Rezoning Transportation Analysis
Petition Number: Insert Zoning Petition #2021-241
General Location Identifier: 10537220

Date	Description
03-21-2022	First Review (AO)

Transportation Summary

REZONING SKETCH PLAN
2021-241
 FOR
EAST WT HARRIS
APARTMENTS
 2135 E WT HARRIS BLVD
 CHARLOTTE
 MECKLENBURG COUNTY
 NORTH CAROLINA

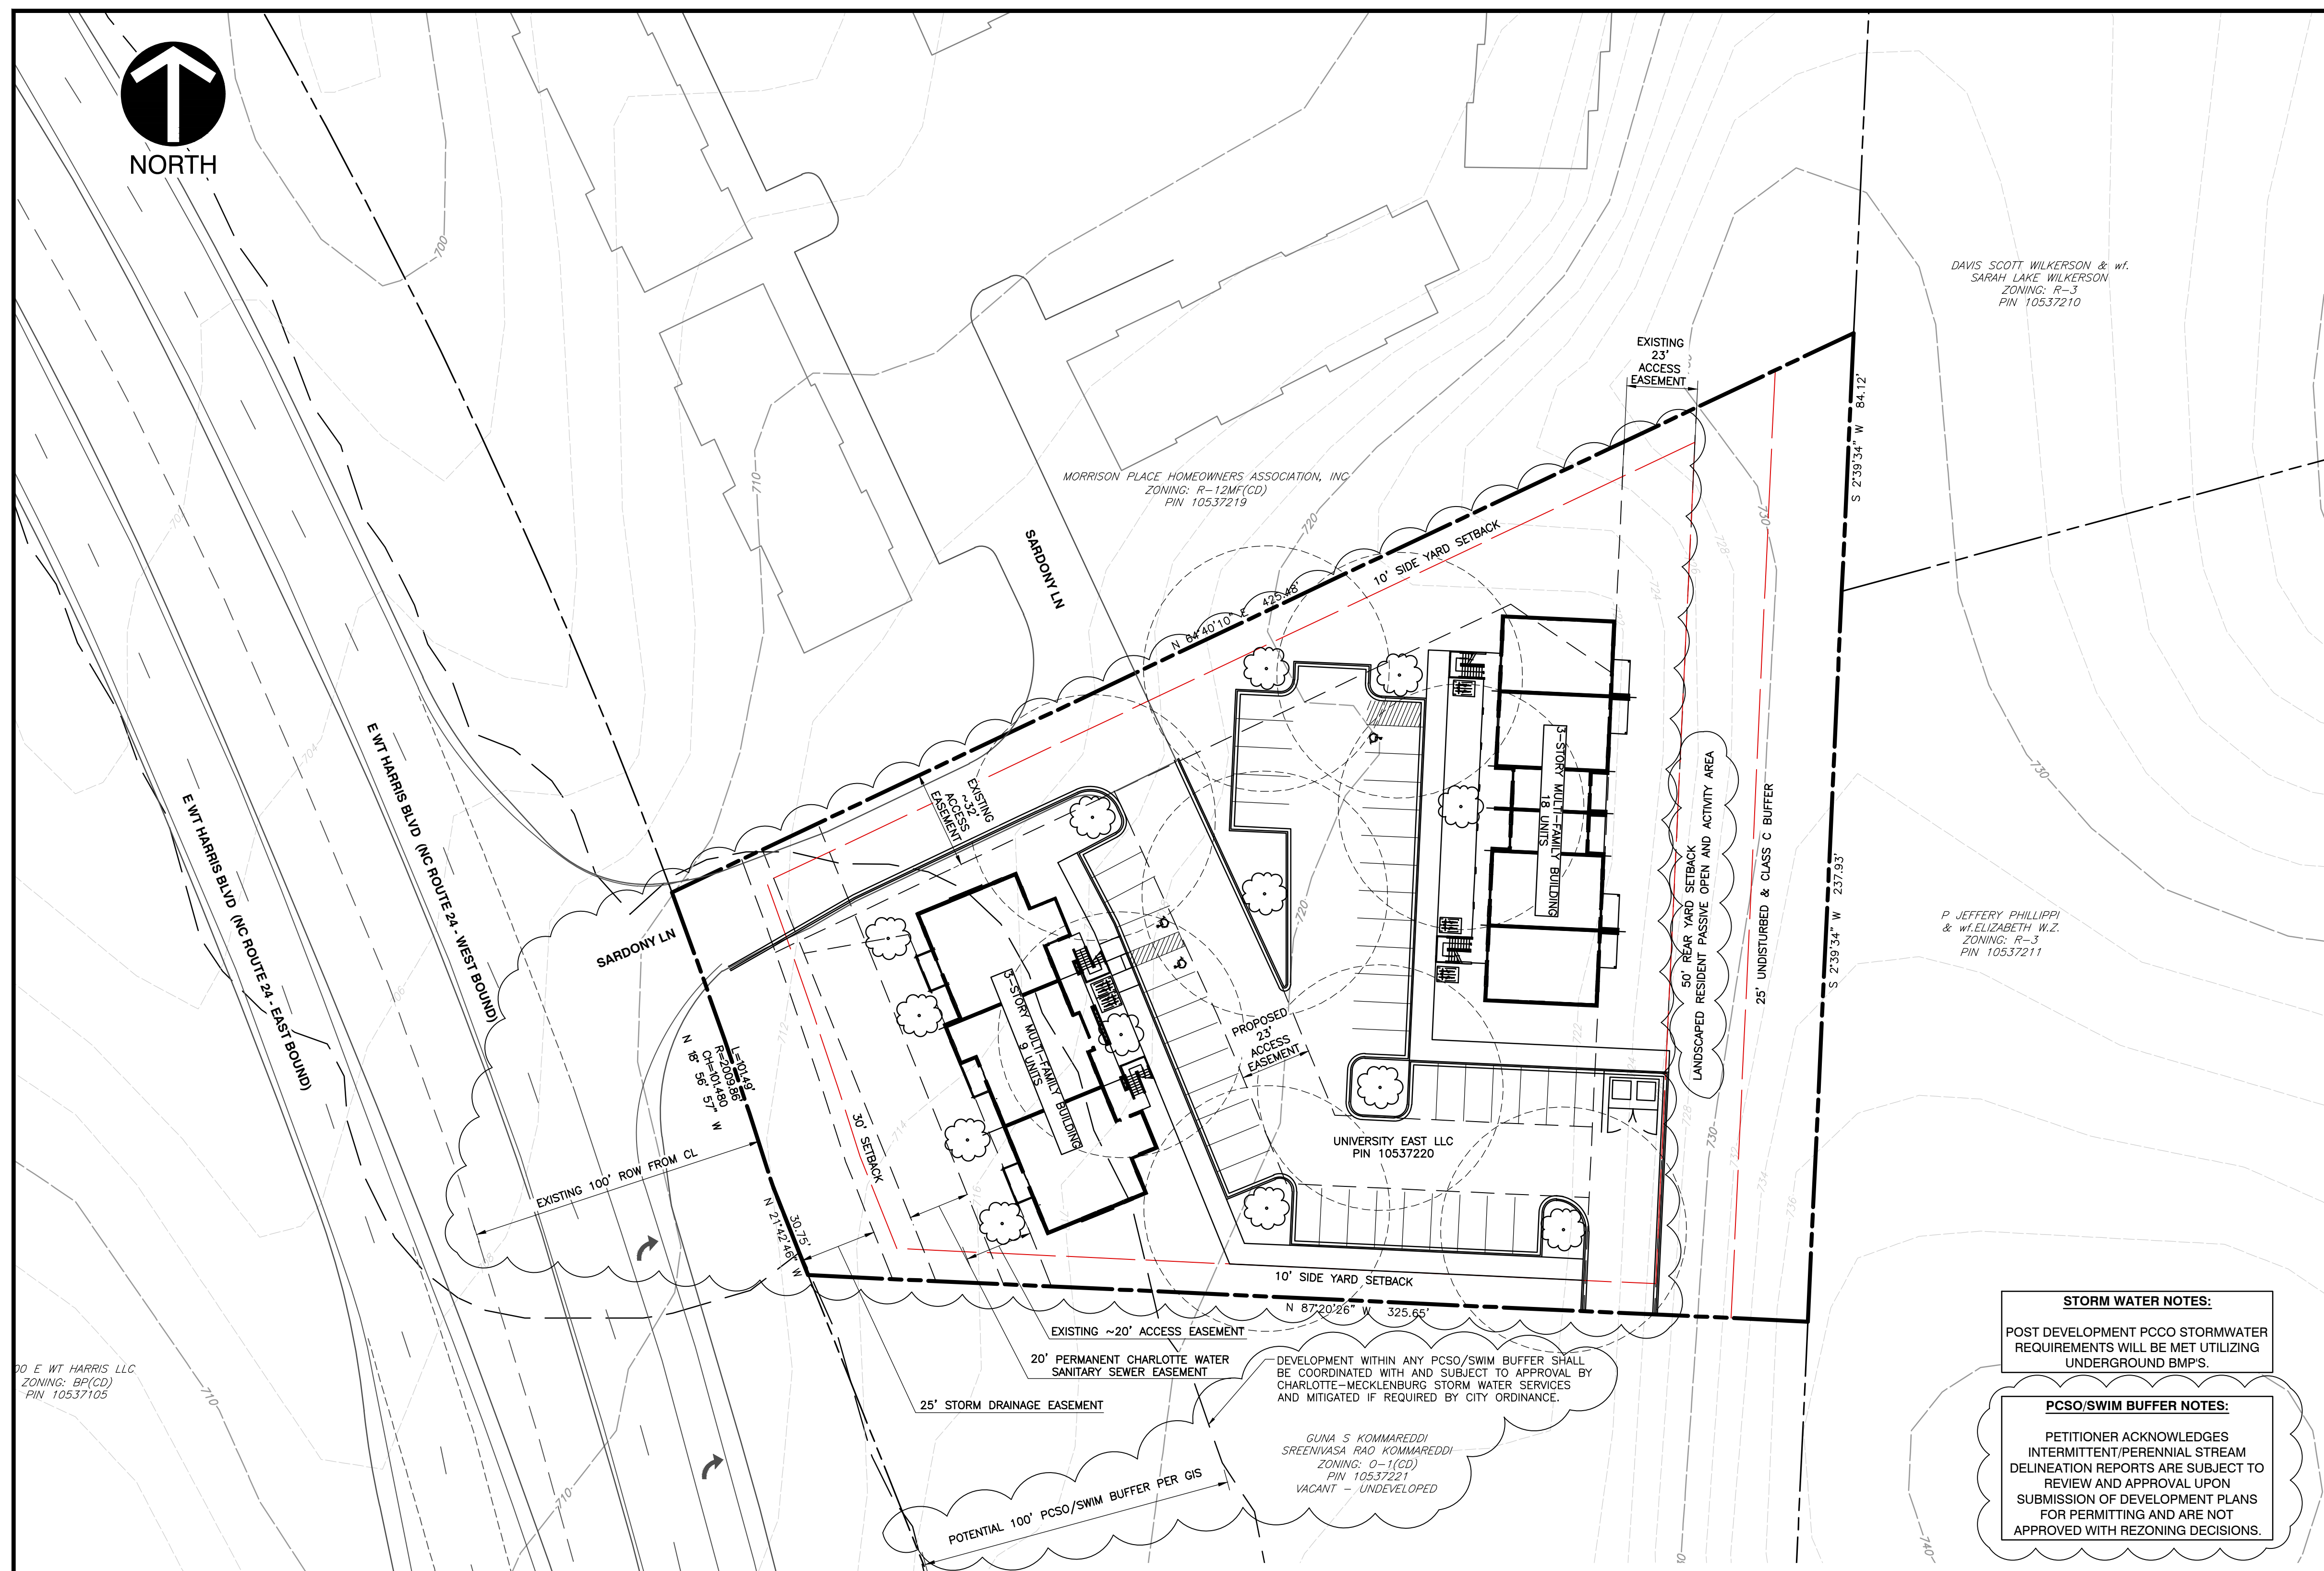
2. Revise site plan and conditional note(s) to commit to dedicate 100 feet of right-of-way from the road centerline of WT Harris Blvd. The site plan shall label and dimension the right-of-way from the road centerline.

3. Revise site plan to align proposed driveway aisle with existing Sardony Ln.

DRAWING NO: **SP-1**

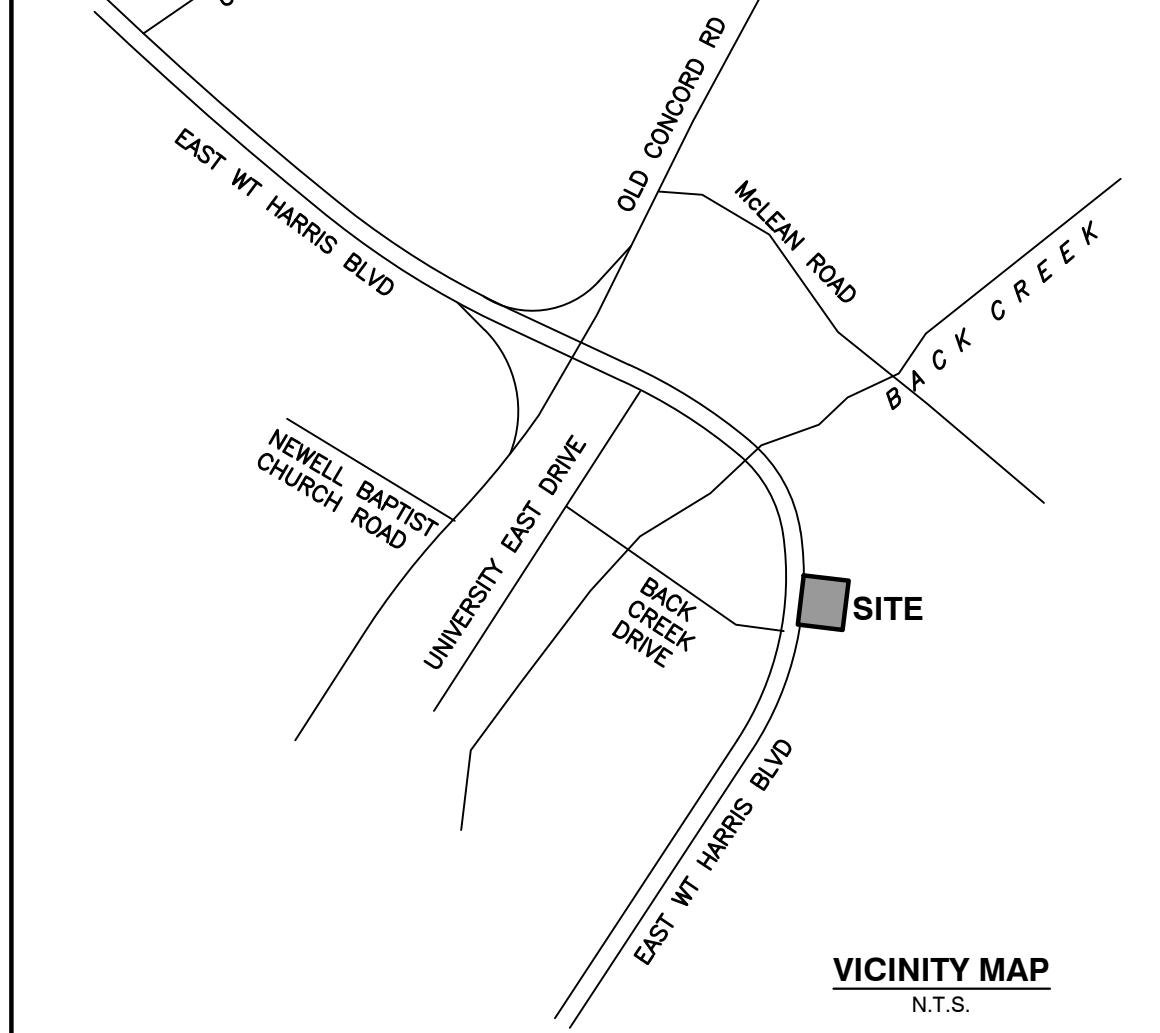
4. A site plan note(s) specifying dedication and fee simple conveyance of all rights-of-way to the City before the site's first building certificate of occupancy is issued as needed. CDOT requests rights-of-way set at 2' behind back of sidewalk where feasible.

5. A site plan note specifying that all transportation improvements will be approved and constructed before the site's first building certificate of occupancy is issued as needed. The petitioner may phase transportation improvements if said improvements and phasing are explicitly described in site plan notes.

6. Add conditional note "All public roadway improvements will be subject to the standards and criteria of CDOT and NCDOT, as applicable, to the roadway improvements within their respective road system authority. It is understood that such improvements may be undertaken by the Petitioner on its own or in conjunction with other development or roadway projects taking place within the broad north eastern Mecklenburg area, by way of a private/public partnership effort or other public sector project support."
